SUBMISSION ON BEHALF OF IRISH LIFE ASSURANCE PLC. ('ILA')

– Metrolink Hearing – 21st March 2024

LOWERING OF TUNNEL UNDER CADENZA AND AMENDMENTS TO THE EIAR

Oral Hearing – Metrolink - ABP Ref 314724-22 – Observer: Irish Life Assurance plc.

TUNNEL ALIGNMENT
SAINT STEPHEN'S GREEN – CHARLEMONT
RO APPLICATION VS DEEPER VERTICAL ALIGNMENT OPTION

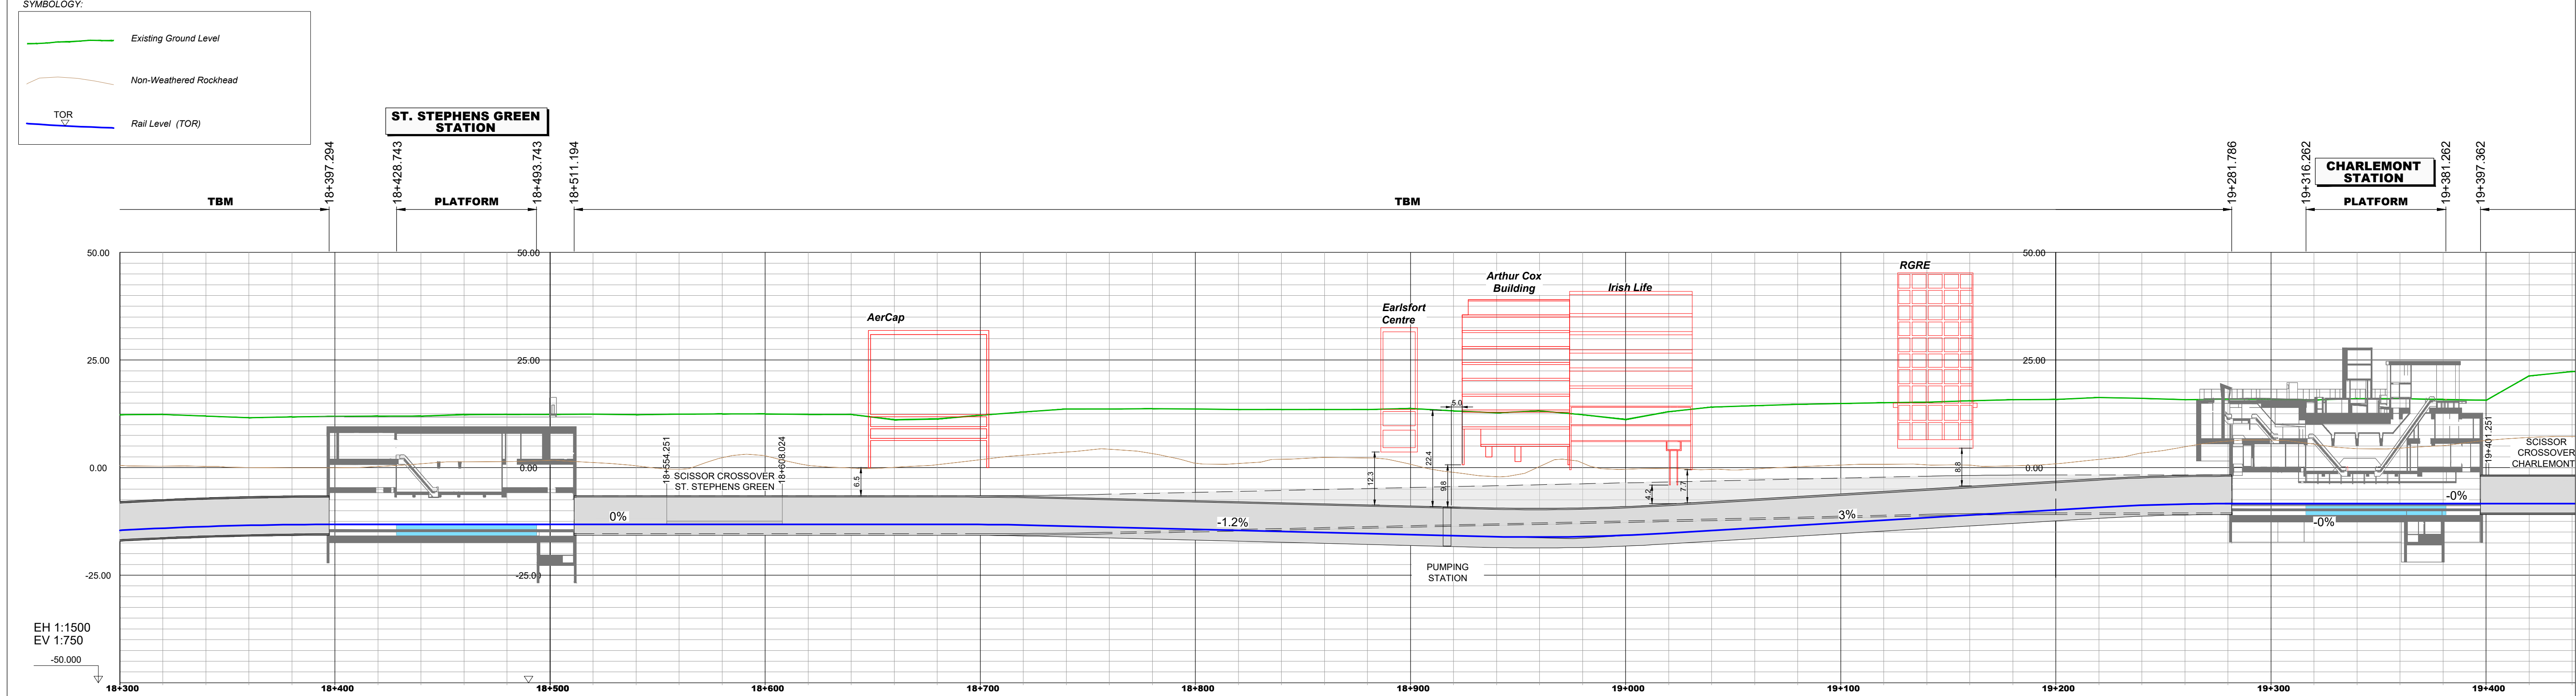
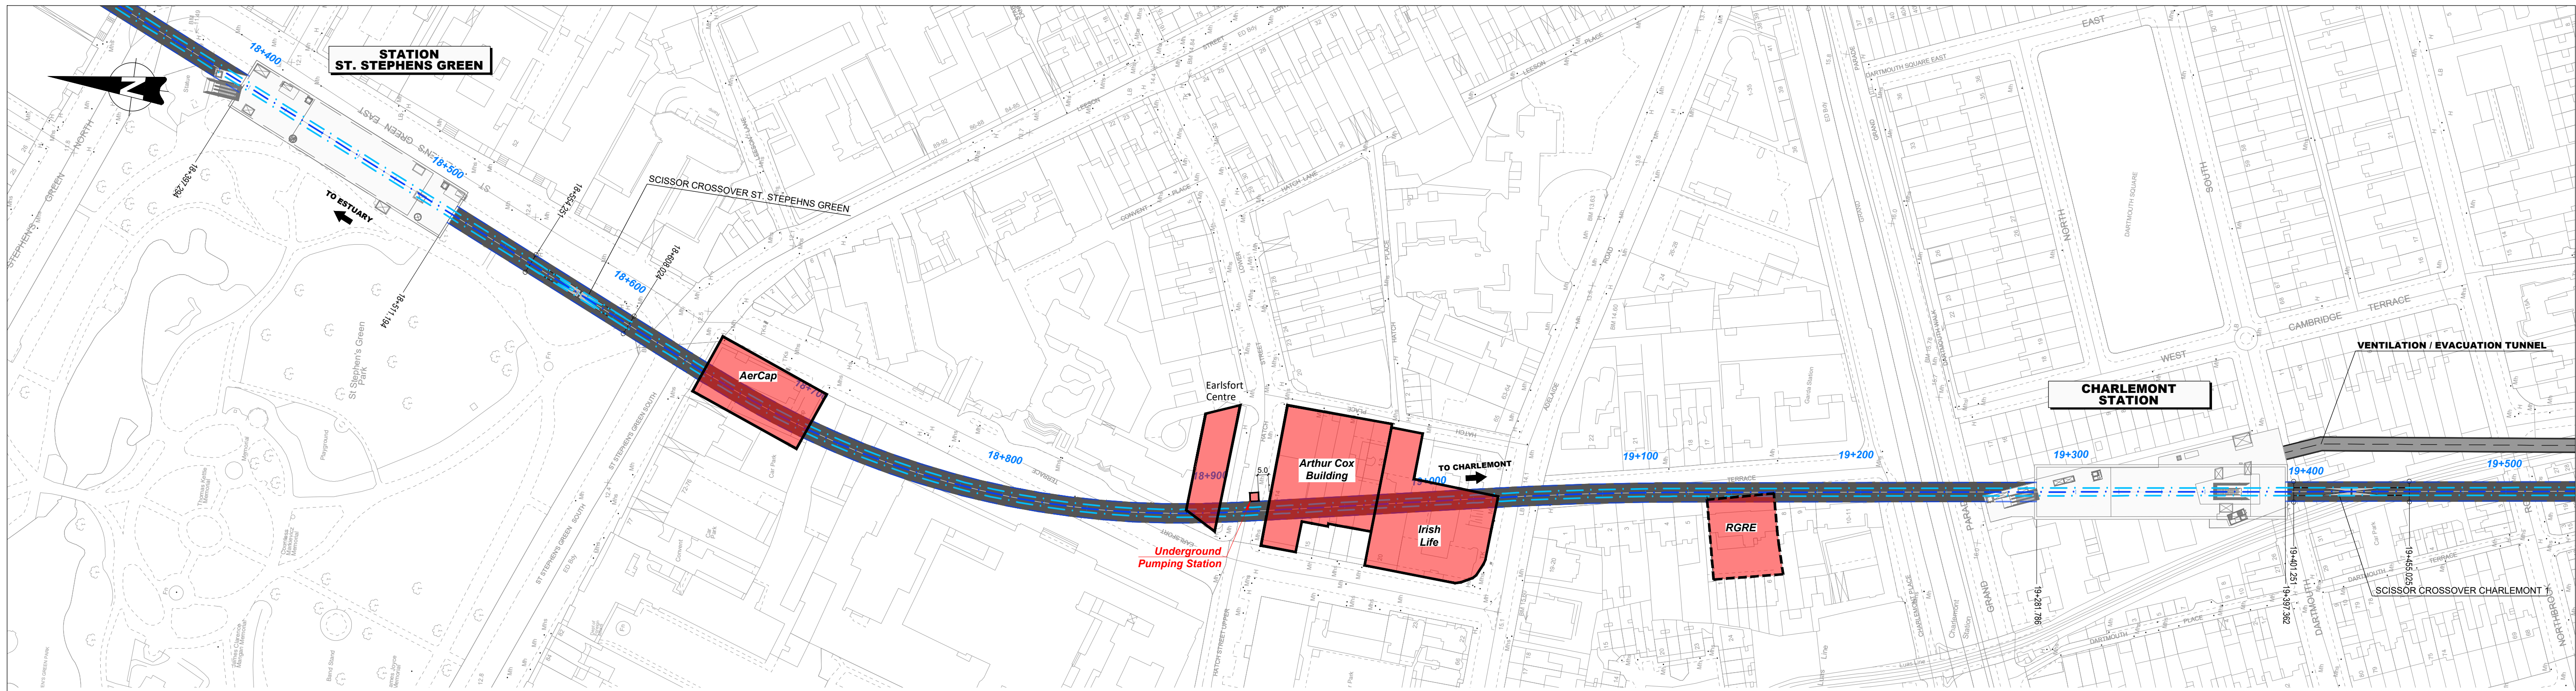
Additional information has been submitted to the Oral Hearing by TII including an Addendum to the EIAR and additional drawings showing that the metro tunnel depth is to be dropped by c. 5 metres relative to its initially proposed depth underneath the Cadenza building.

Nevertheless, having reviewed the additional information submitted to the Oral Hearing, ILA has residual concerns.

- Whereas an updated EIAR/addendum to the EIAR (including the outcome of a Phase 2a Building Damage Assessment) has been produced, the evidence from ILA's expert engineers will be that there are still serious concerns about the impact of the development on the integrity of the Cadenza building and its façade.
